**Our ref:** WA/2023/130308/01-L01  
**Your ref:** 23/00417/DISC  
**Date:** 30 March 2023

**Discharge Of Conditions 12 (Construction Management Plan), 13 (Landscape Environment Management Plan), 14 (Construction Environment Management Plan), 21 (Woodland Management Plan) And 31 (Habitat Management Plan) Of 22/01144/F**

**OS Parcel 5700 South West Of Grange Farm, Street Through Little Chesterton, Chesterton**

drawing title	Detailed Landscape Proposals	Sheet 1 of 17
date	18 OCTOBER 2022	drawn by LCH
drawing number	edp2425_00171	checked BC
scale	1:1500 @ A0	QA RB

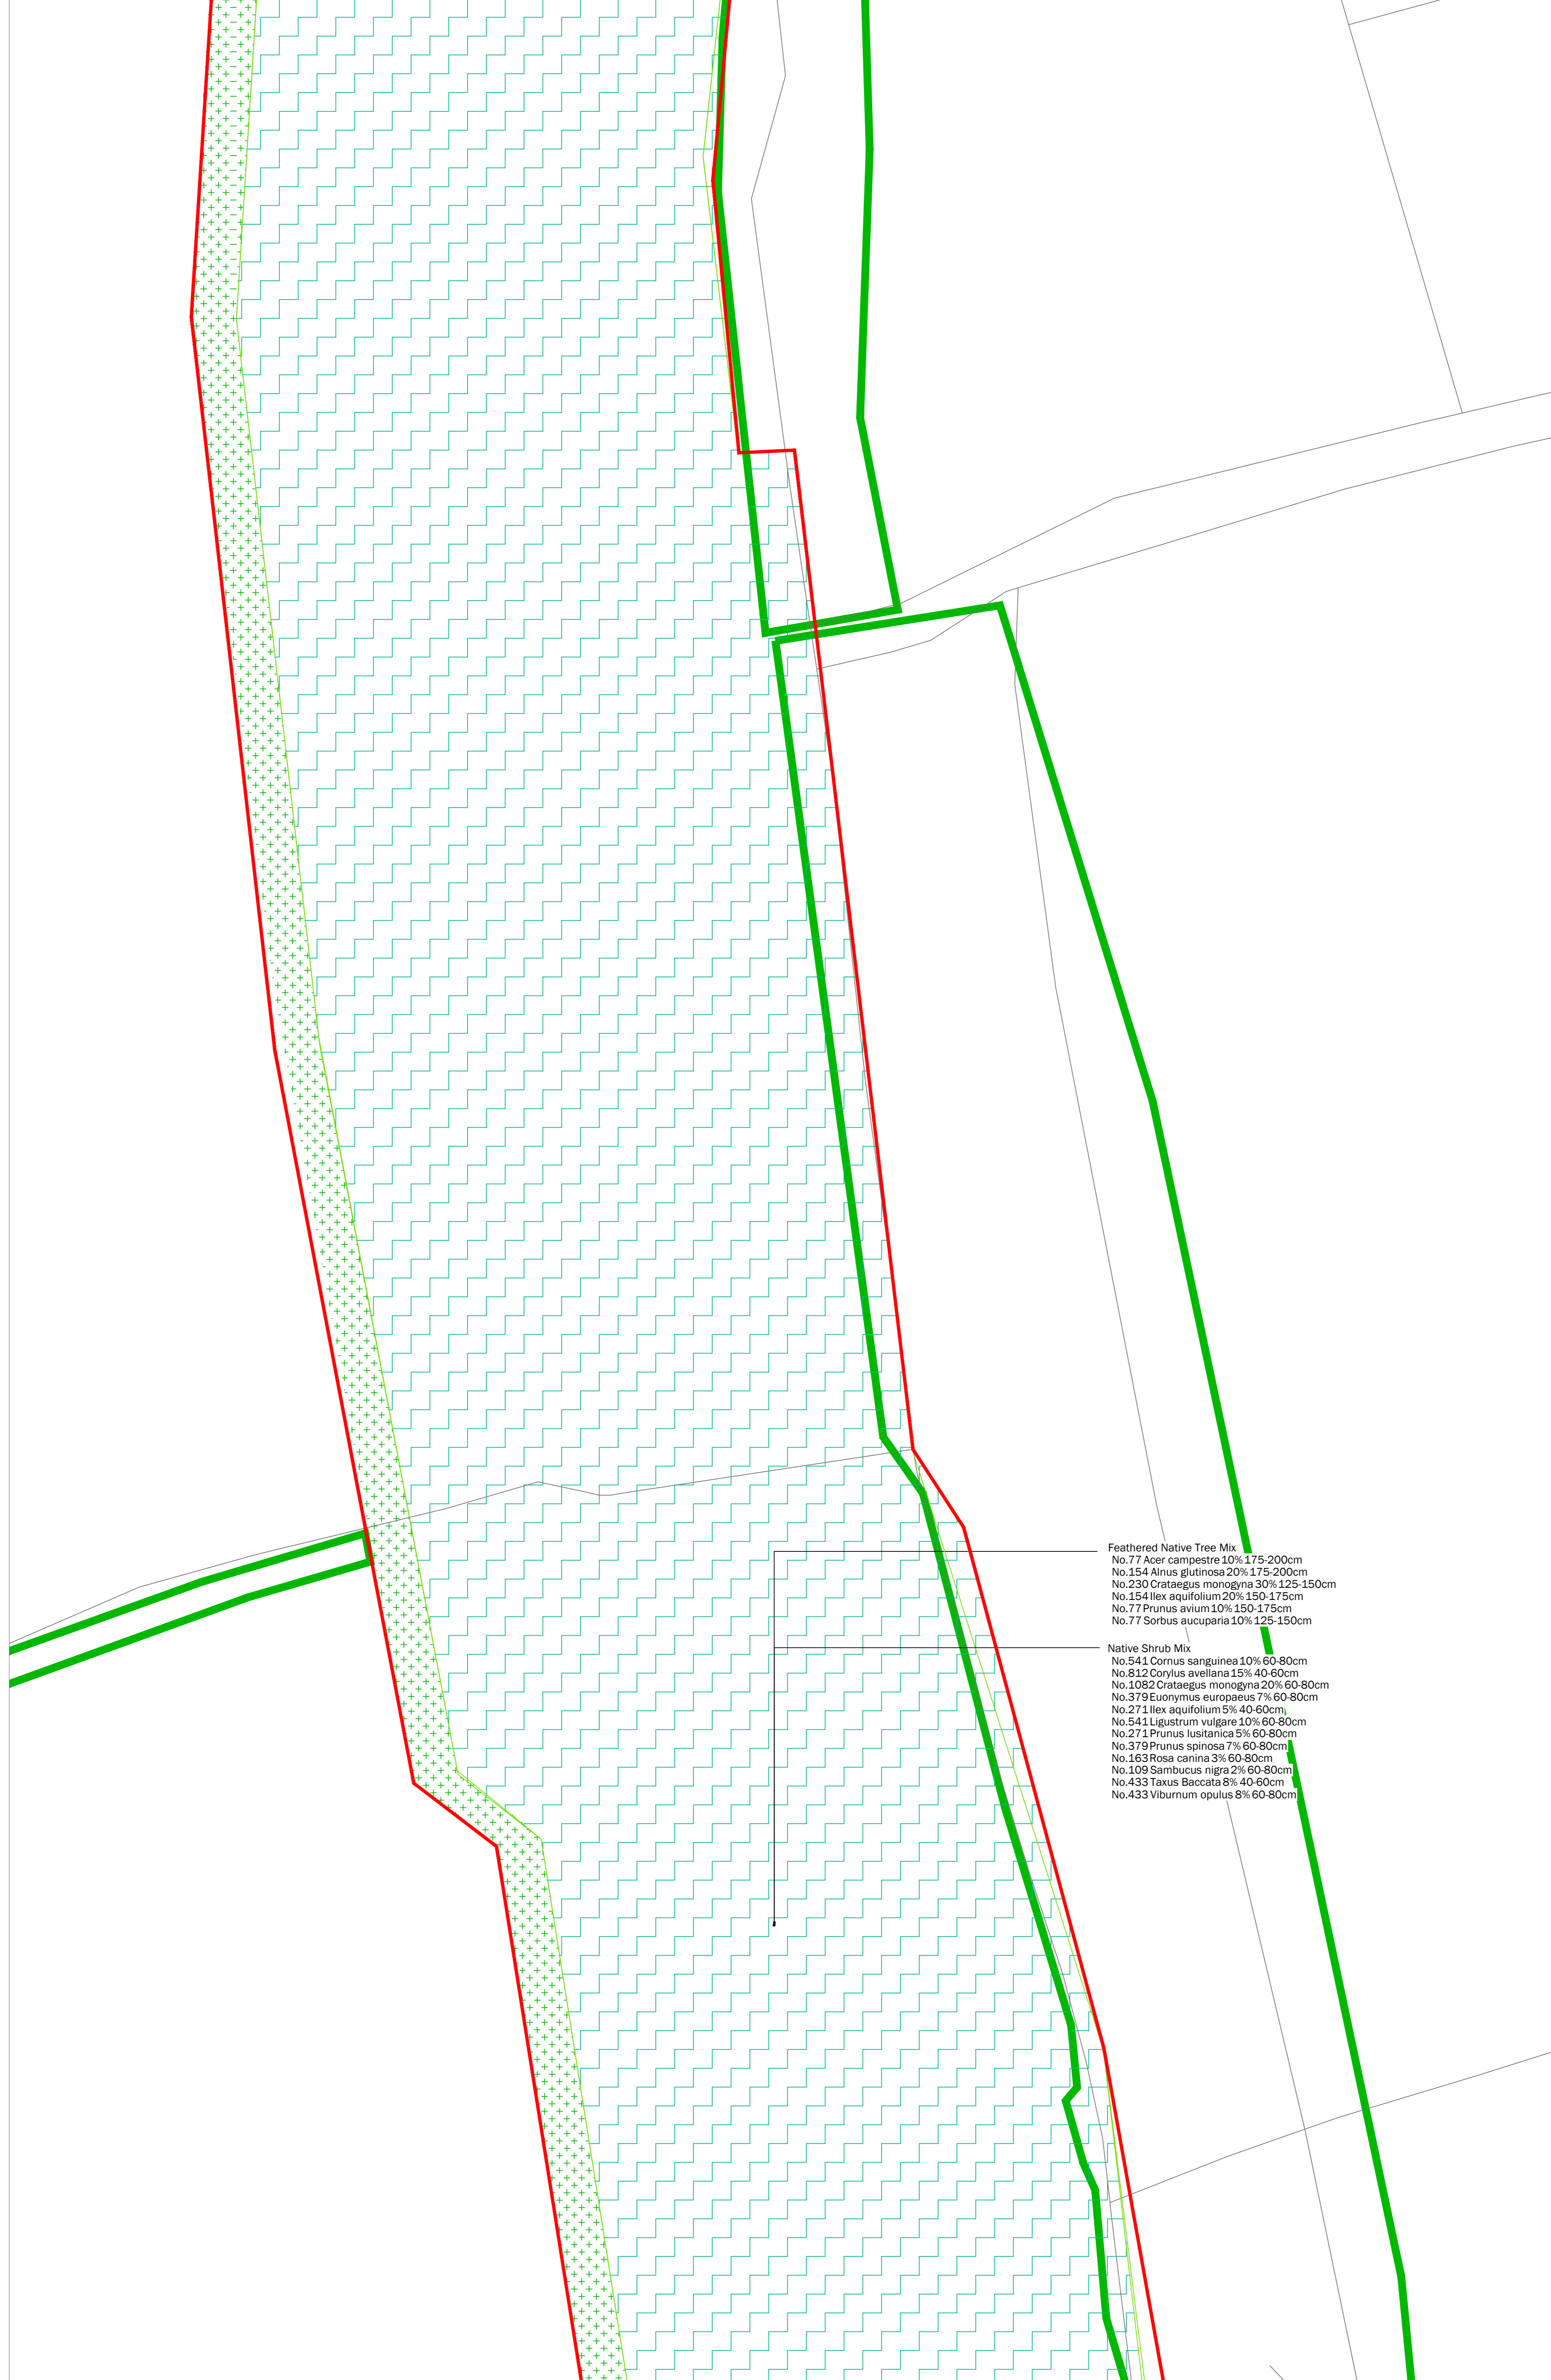
- The Biodiversity Protection Zones plan and Appendix 2: Landscape Planting plan in the CEMP show some protective fencing on the bank top of the Wendlebury Brook, this should be revised to allow mammal passage along the river corridor by setting any fences back from the bank top. The positioning of this fencing should be accurately identified in the CEMP and LEMP and not left as a decision for the contractor.

- There is no sheet to cover the furthest extent of the brook before it crosses the main road (i.e., Northeast of sheet 7). The LEMP should cover the maintenance of an ecological buffer zone for the entire length and both banks of the watercourse where it is not culverted.

The ecological buffer zone is required along the entire length of the watercourse and on both banks except where a culvert takes the flow under the access road and main road. The Biodiversity Protection Zones plan and Appendix 2: Landscape Planting plan in the CEMP appear to show the ecological buffer stopping short of the access road and not

These plans also show that the buffer is often only on one side of the watercourse and likewise the section north of the Ancient Semi-natural Woodland is not coloured to show habitats to be retained but appears to be within the site boundary.

Furthermore, the plans show fences on the bank top, this is unacceptable. All fences need to be moved back to the edge of the ecological buffer zone to allow movement of fauna through the river corridor.
